**Consultation Response from KC,
Highways Development Management****2023/91483 adj, 33a, Church Lane, Clayton West, Huddersfield, HD8 9LY****Demolition of garage and erection of detached dwelling****Date Responded: 14/11/2023.****Responding Officer: D. Stainsby****Responding Ref: K17-38/52****RECOMMENDATION:**

PROPOSED SITE PLAN

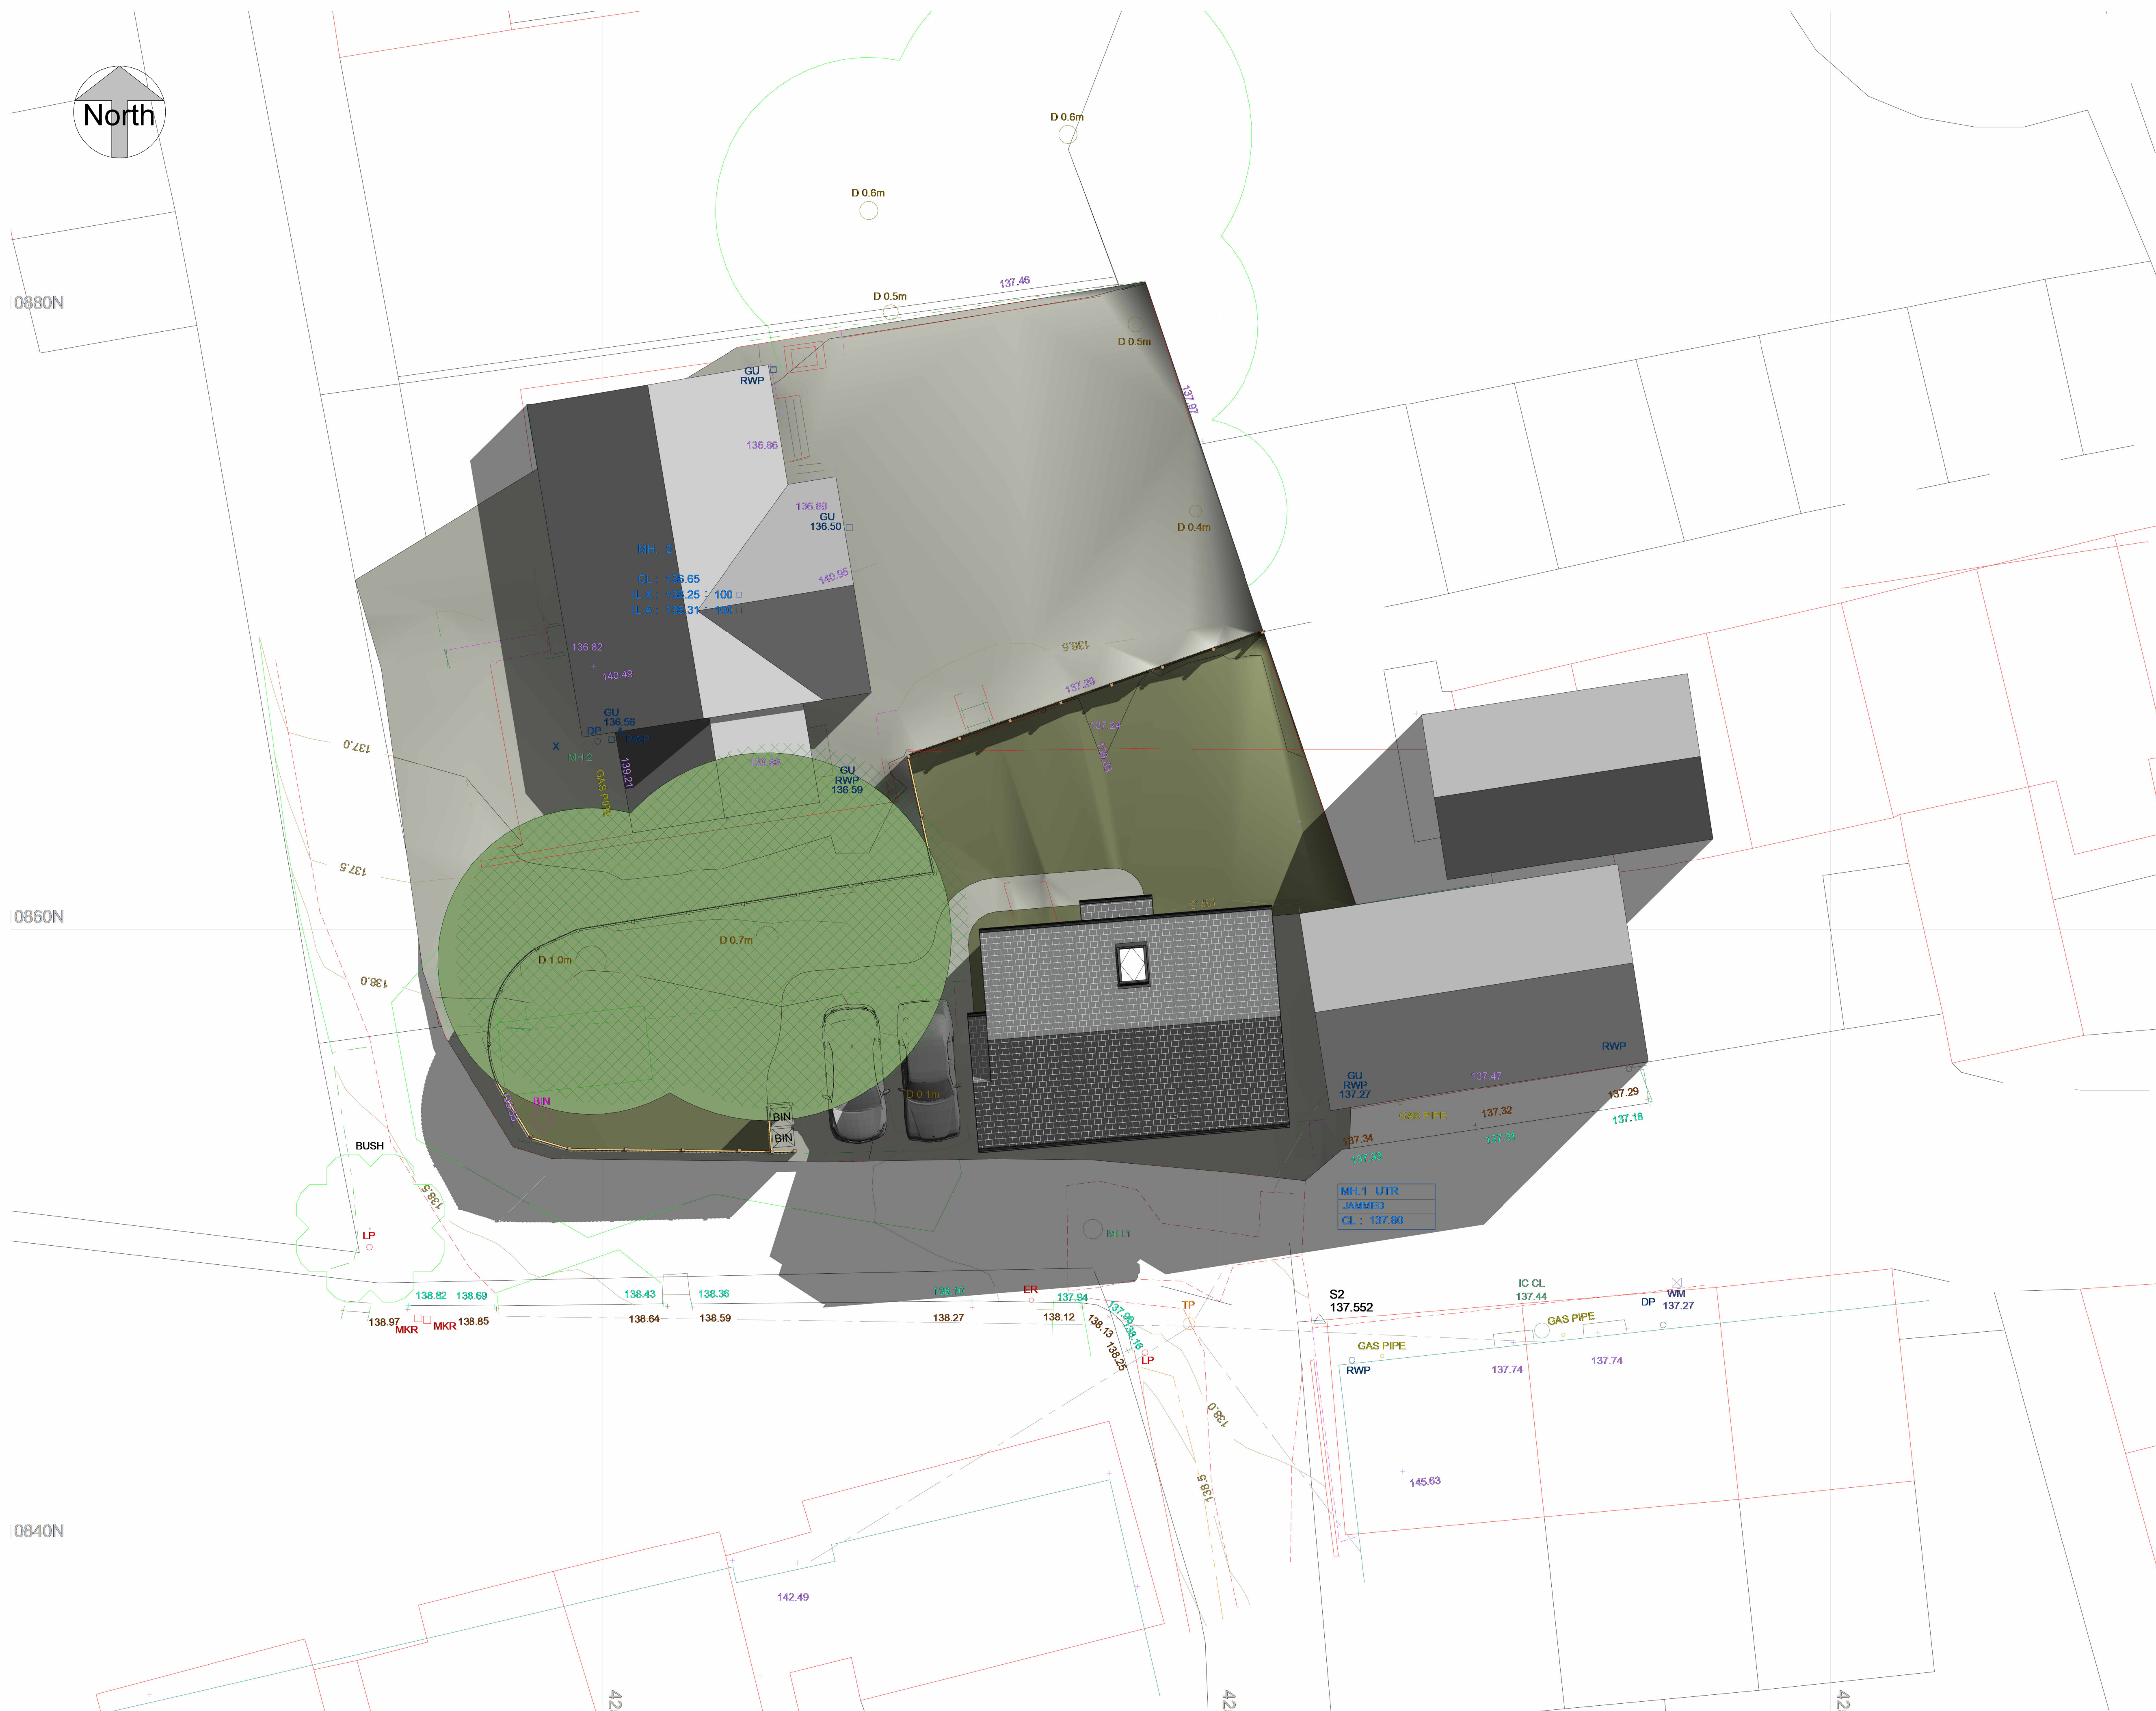
The level of parking provision proposed is acceptable for a 3 bedroomed dwelling and is in accordance with the guidelines as prescribed within the Kirklees Highway Design Guide. However, the site layout does not satisfactorily demonstrate that sufficient turning and manoeuvring space would be available to serve the proposed development.

The proposal shows two parking spaces which are acceptable but the width of Holmfield at this point is narrow and the access and egress to the spaces appears to be very tight and would result in vehicles carrying out several turns to access the parking area. Especially if one of the spaces is occupied.

A swept path analysis to show that the vehicles can access and egress the parking spaces safely needs to be provided.
